Subject: EP/39/22/PL 29 Tamarisk Way

Apologies for the delayed response relating to the above application which was recently transferred over to me. Having now looked through the application documentation and recent correspondence with Obafemi and having had the chance to discuss the case with Juan, we feel that the loss of the eyebrow dormers would have a detrimental impact to the character of the building.

Proposed Roof Plan
1469/NA18A
Scale 1:100 at A3 .

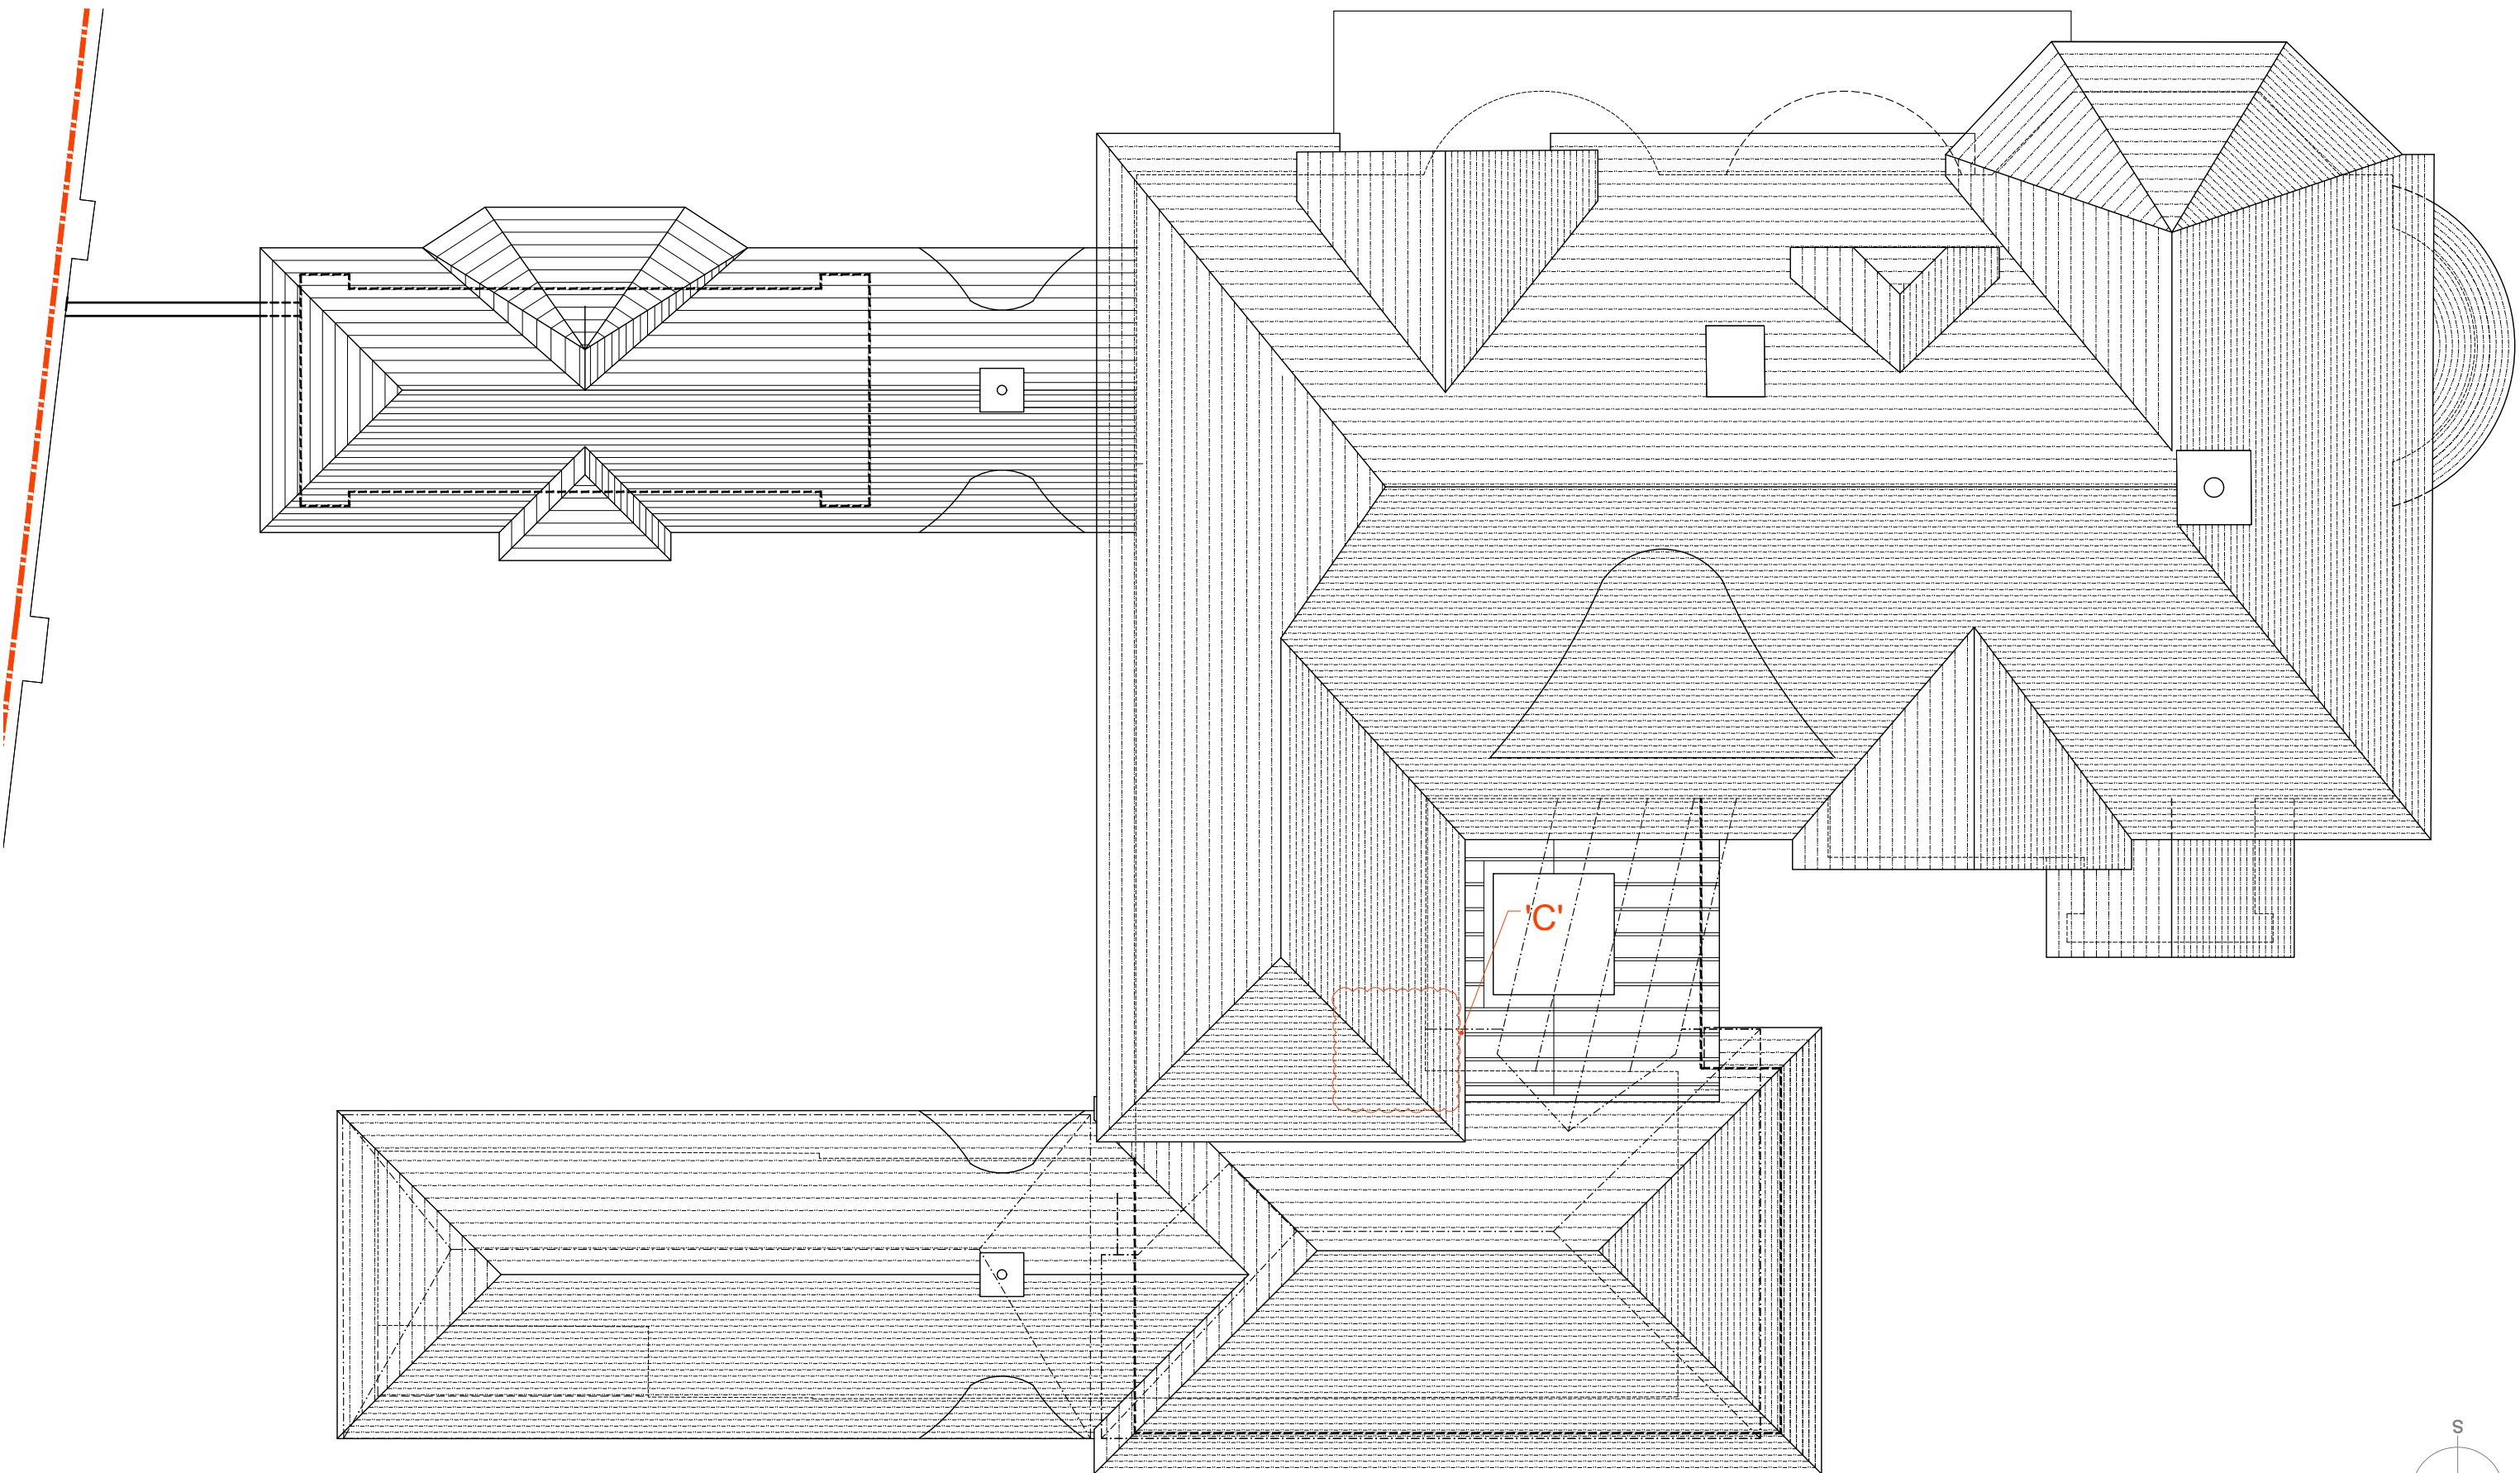
As a Locally Listed Building any alterations are expected to relate sensitively and respect the architectural interest as per Policy HER DM2 of the ALP. As stated above the eyebrow windows form part of the character and as such we seek to preserve these features of interest. I understand that there are difficulties relating to the rainwater gear however, technical matters of design are not a concern for planning, and we would request you seek an alternative method to install the guttering whilst maintaining the special architectural features of the building.
